A. A. Takla Engineering, PLLC

Project: 224 Sneed Ln.
Location: Fuquay Varina, NC
Company: Gutierrez Framing
Care Of: Alex Mejias
Subject: Framing Items
Job Number: 1582-23

As requested, Andy Takla, PE visited the above referenced site on October 3rd, 2023 to review the following framing items presented to engineer by the framing contractor:

1ST FLOOR FRAMING PLAN
ELEVATION A
WALLS AND CEILING
1/8" = 1'-0"

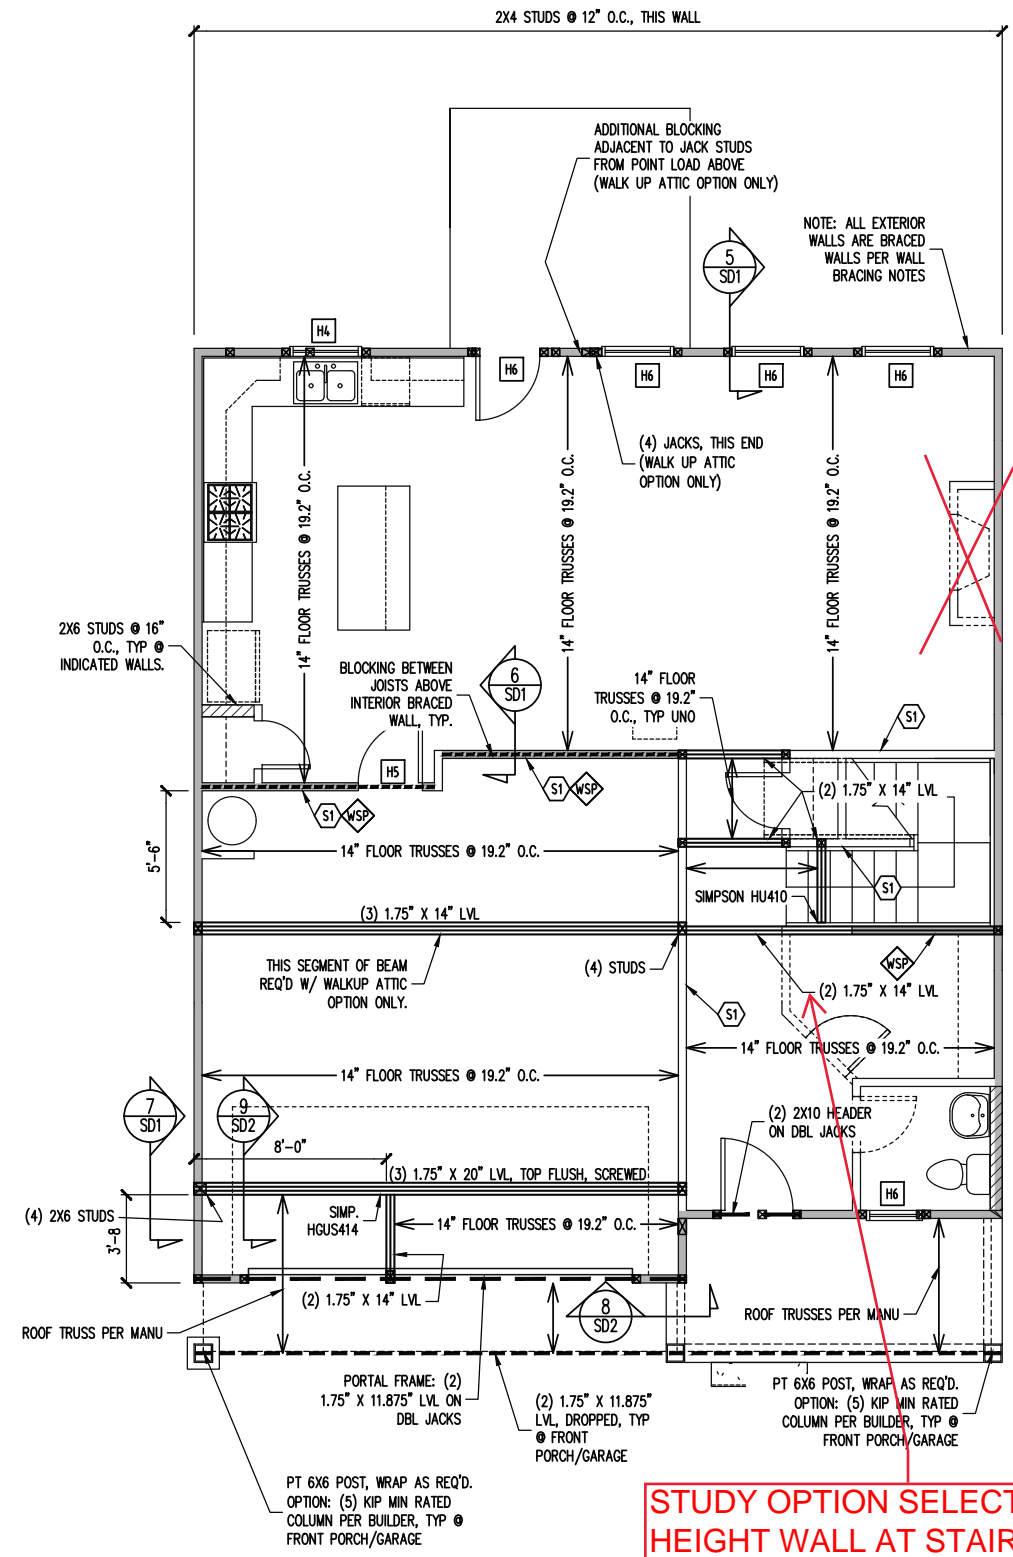
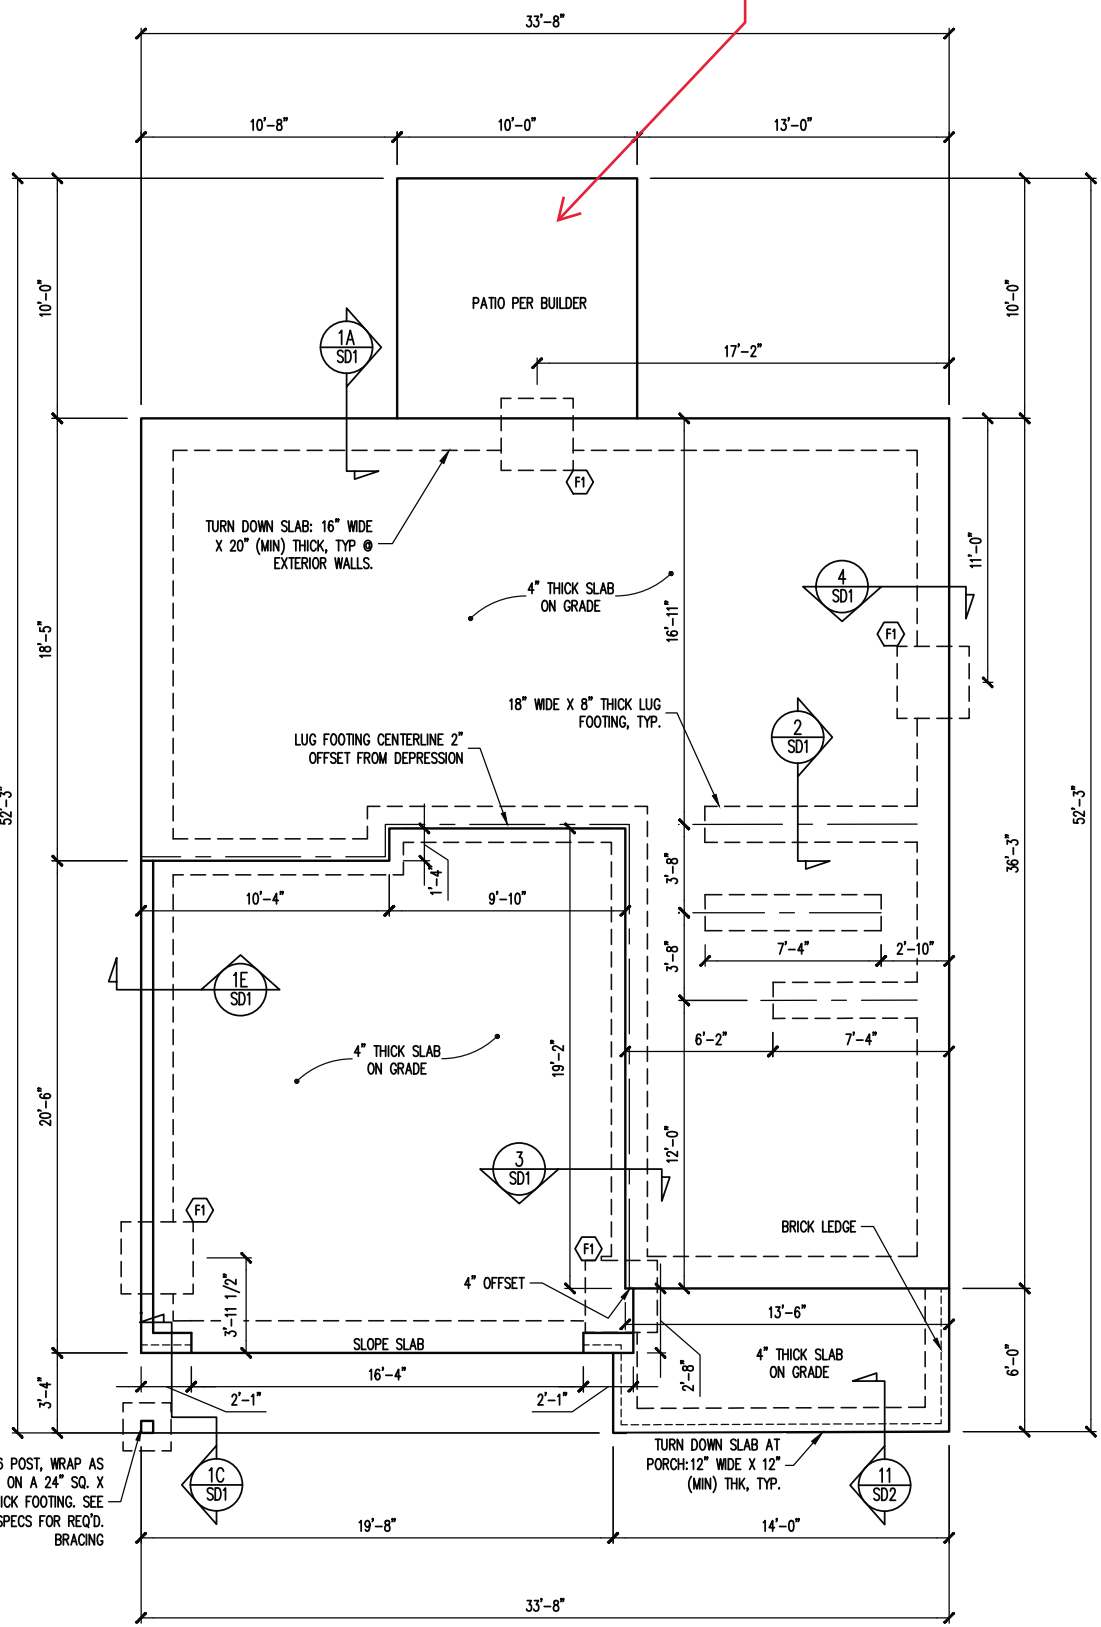
- 2) The per plans (2)14" LVL in-line with the forward stairwell wall (in 1st story ceiling) does not extend to the right exterior wall as specified in the plans; Instead it stops at the right foyer wall (unfortunately where no lug footing exists). Based on review **we recommend removing the OSB sheathing attached to the front face of the front stairwell wall, cutting the bottom 14" of all studs in this wall (including the stud column which support the right end of the (2) 14" LVL beam), and install a (2) 14" LVL beam extending from the right exterior wall to the aforementioned stud column. Allow beam to continuously bear on the bottom plate. It is acceptable to notch the beam as required about any anchor bolts. Thereafter, reapply sheathing. This repair is intended to support the point load via the (2) 14" LVL "in cantilever" as to not apply significant loading on the location of the slab lacking the lug footing.**

2ND FLOOR FRAMING PLAN
WALK UP ATTIC OPTION
ELEVATION A
WALLS AND CEILING
1/8" = 1'-0"

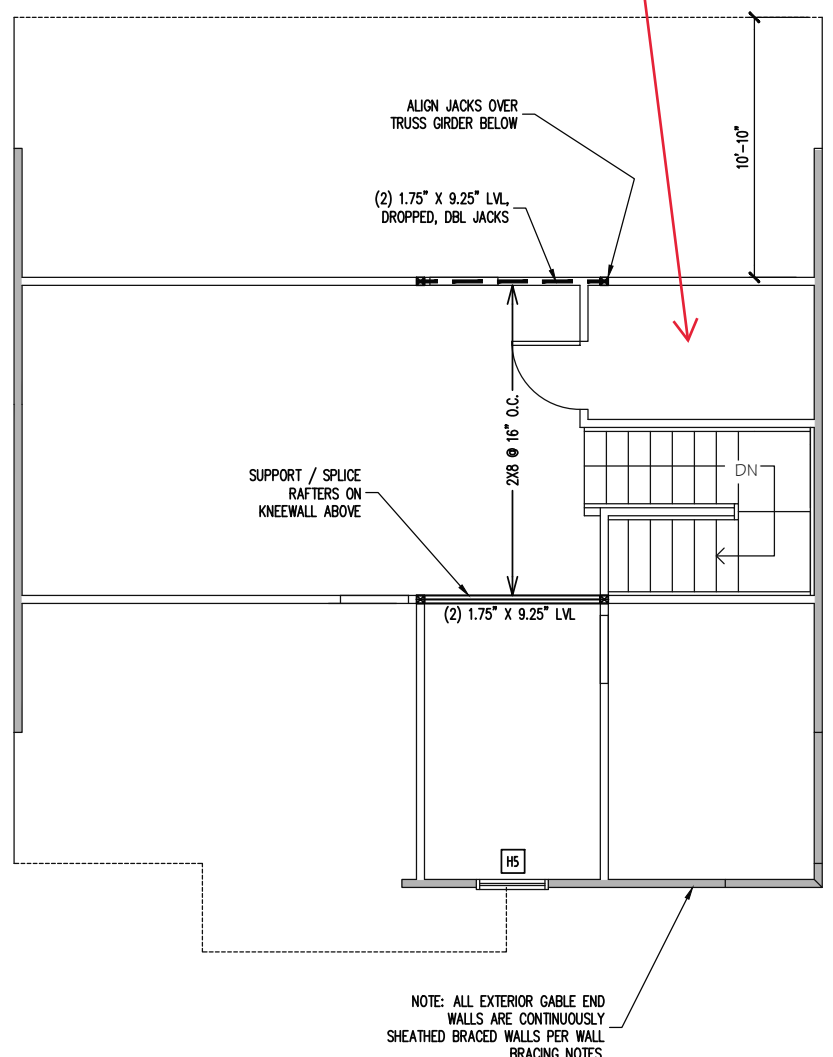
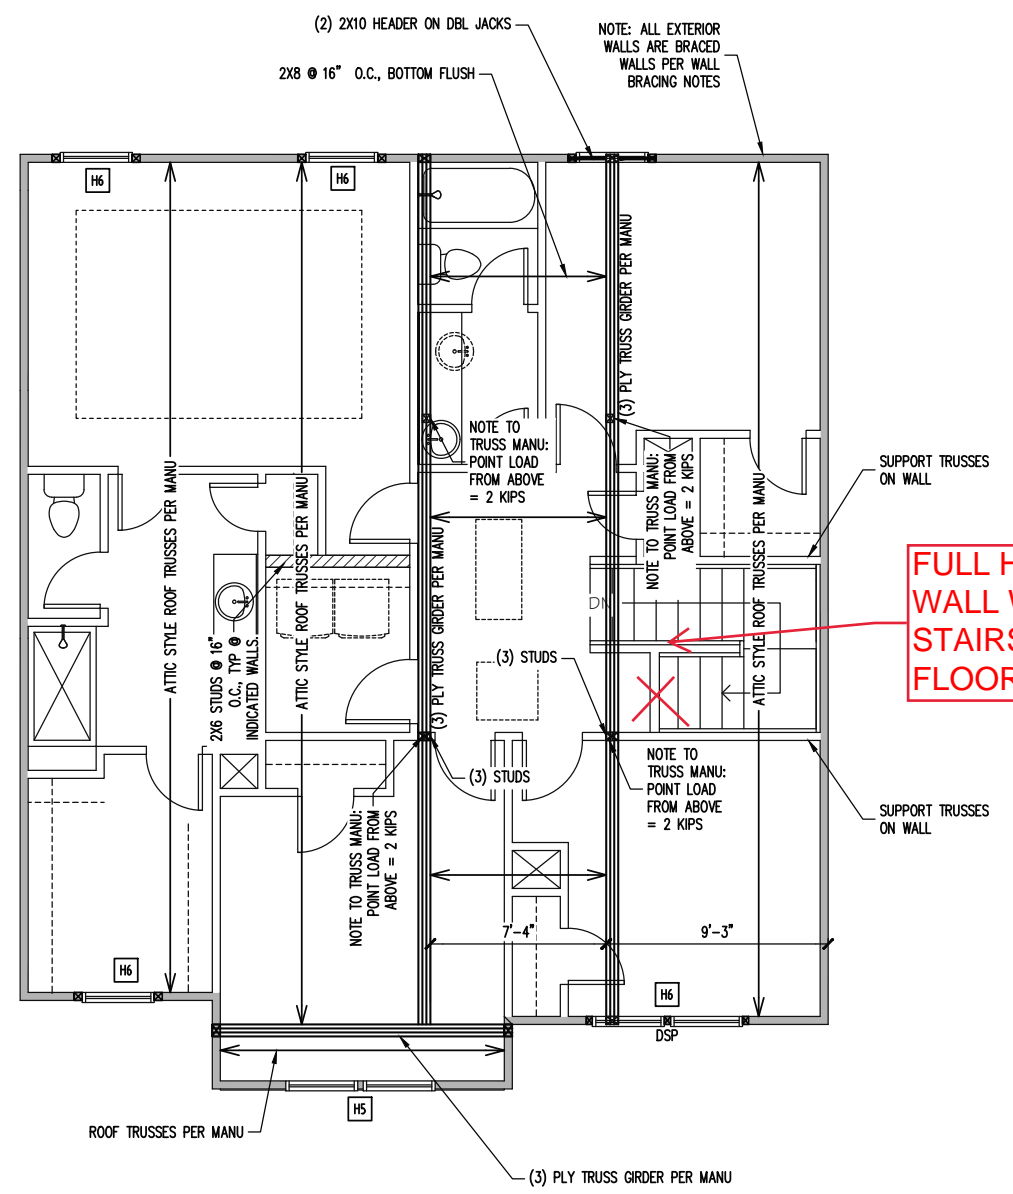
- 3) The framing overhead as one enters the 2nd story (near top of stairs) is framed very differently from the sealed plans. This is primarily a result of an error when designing the right side 3 ply girder roof truss. The girder truss's bottom chord was cut at the stairwell wall to accommodate adequate head room. We understand the framers have implemented changes to this area (to include the installation of three (3) 9 1/4" flush LVL headers to transfer loads to 2nd story walls) as instructed by the truss suppliers. Based on review, the framing is found to be both appropriate and adequate to carry the loads **provided a (4) stud column is installed supporting the right end of the rear (left-right) spanning (2) 9 1/4" LVL at the rear stairwell wall; Install the same (4)2x4 stud column in the 2nd story wall, and 1st story wall to the foundation. No additional foundational reinforcements are required.**

- 4) At least four (4) 2x10 bottom chords of roof trusses to the right of the right side 3 ply girder roof truss at bearings on rear stairwell wall (of 2nd story) are less than adequately bearing on the wall. **Moving forward, we recommend installing a 4' long 2x10 scab to one side of each bottom chord; Allow scab to fully bear on top plate and attach with (3) 10d nails spaced at 6" on center.**
